CITY OF ALBUQUERQUE  
PLANNING DEPARTMENT  
DEVELOPMENT REVIEW BOARD

### **Project# 1009881**

14DRB-70169– SDP FOR SUBDIVISION 14DRB-70245 - PRELIMINARY PLAT  
14DRB-70246 - TEMPORARY DEFERRAL OF SIDEWALK CONSTRUCTION

PRELIMINARY PLAT OF
EAGLE CREST SUBDIVISION
 BEING A RE-PLAT OF LOTS 4-10 AND LOTS 23-29
 BLOCK 28, TRACT A, UNIT B, NORTH ALBUQUERQUE ACRES
 PROJECTED SECTION 13, TOWNSHIP 11 NORTH, RANGE 3 EAST, N.M.P.M.
 ELENA GALLEGOS GRANT
 ALBUQUERQUE, BERNALILLO COUNTY, NEW MEXICO
 DECEMBER 2013

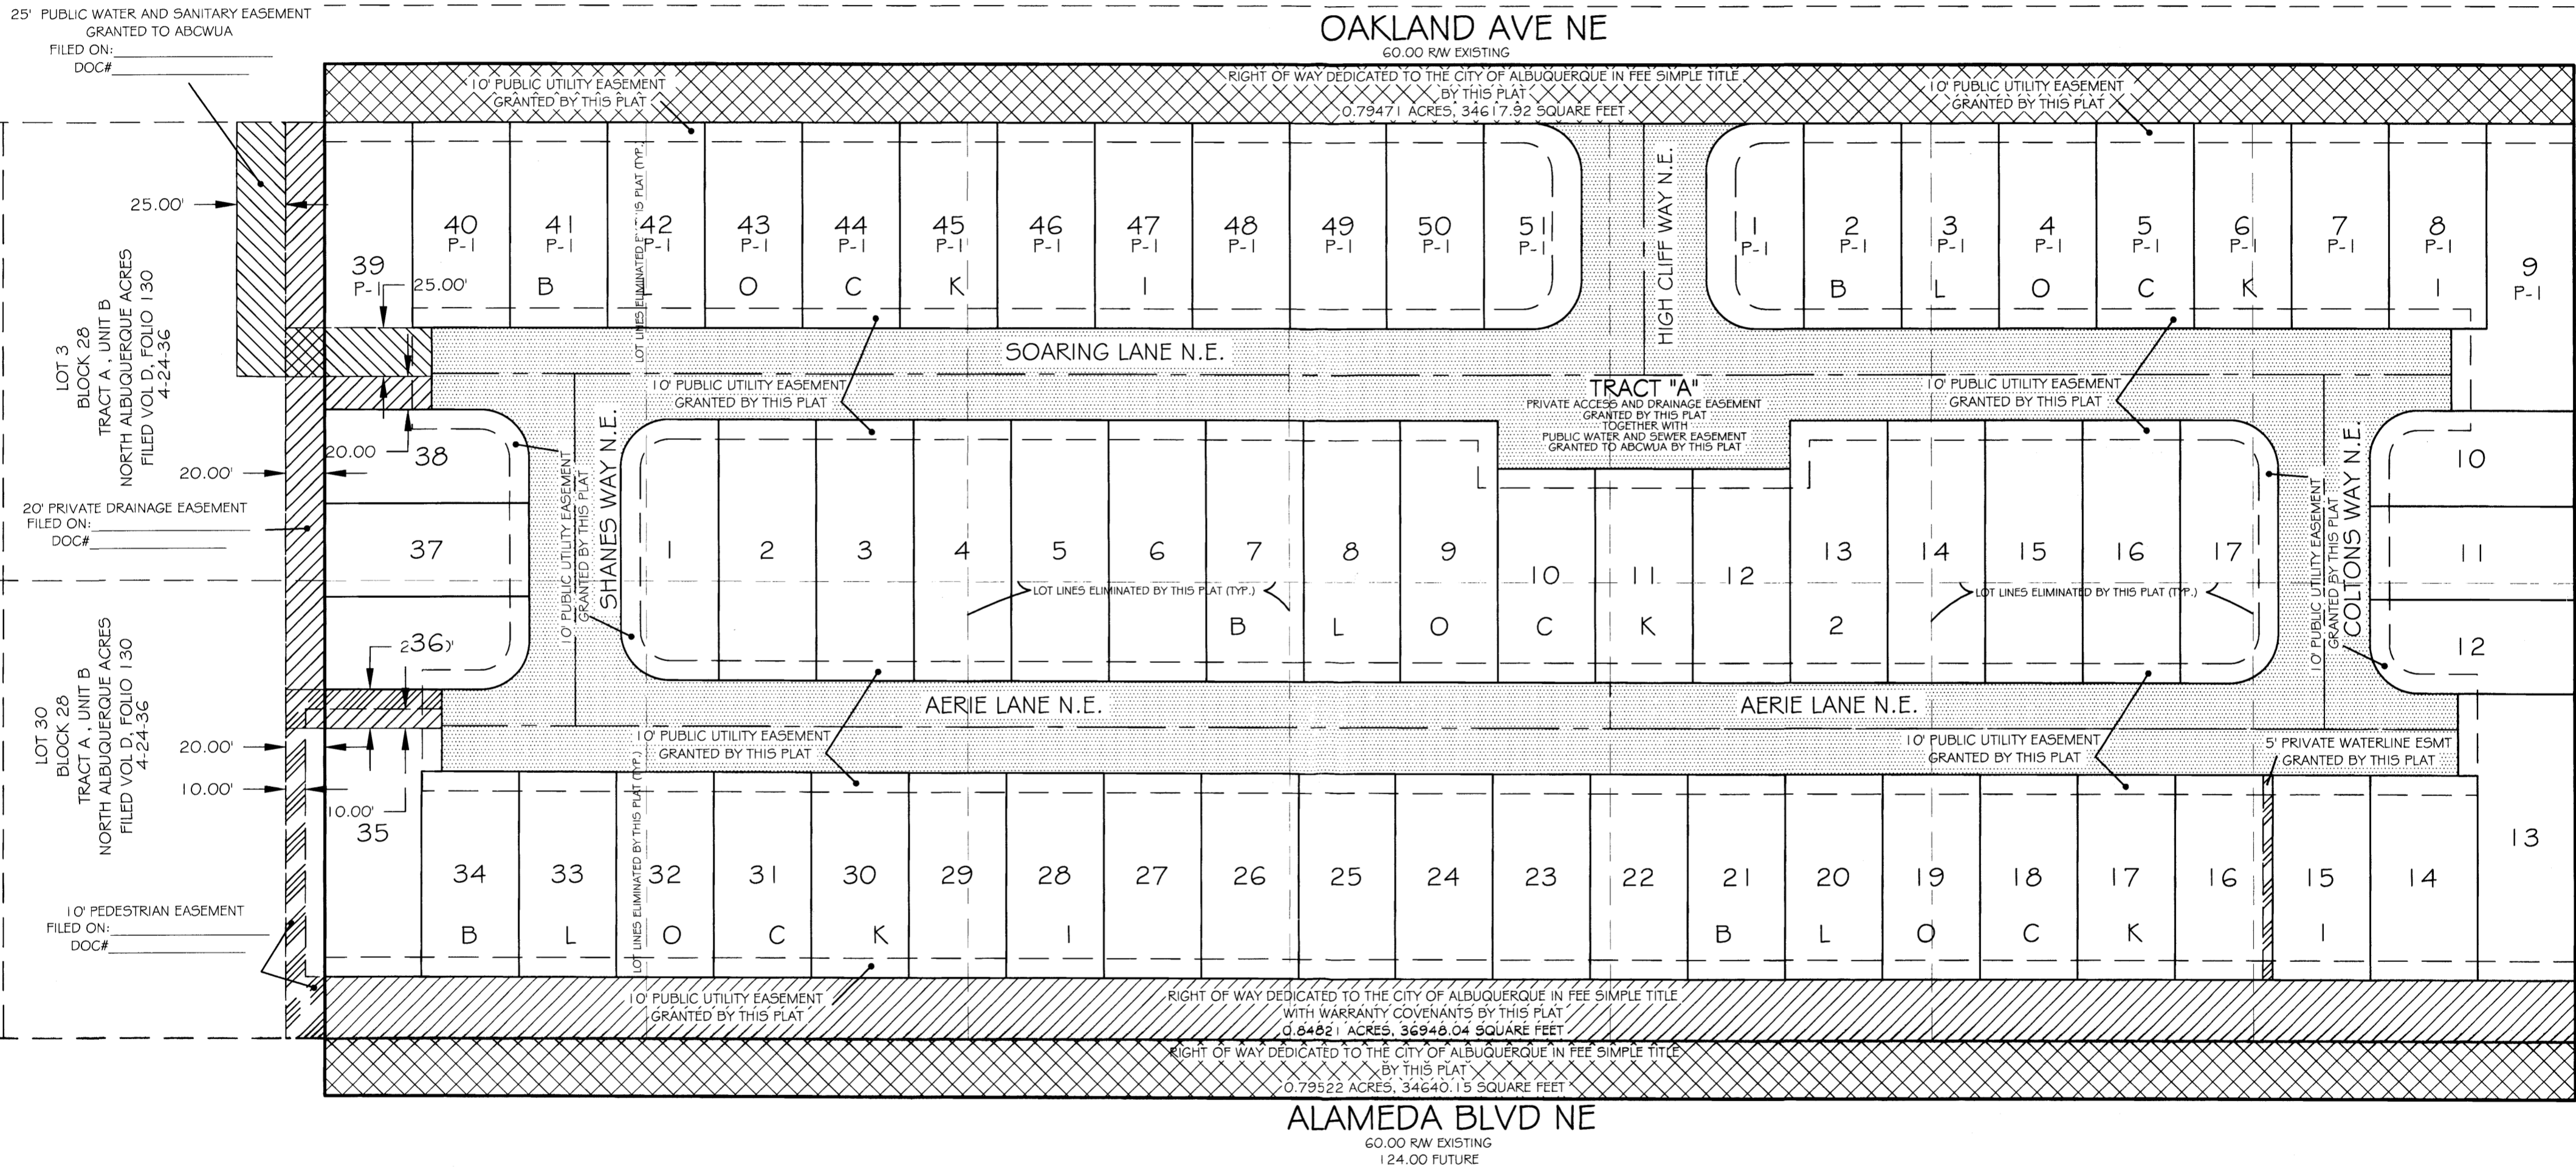
Conditions of final plat include 1) completion of a Landscape Agreement with the City, 2) show the Flood Zone on the plat and/ or add a Flood Zone note, 3) expansion of the Temporary Drainage Easement to 60' x 60' to match the approved Grading Plan, and 4) a recorded Subdivision Improvements Agreement with financial guarantees or completion and acceptance by the City of Infrastructure Improvements.
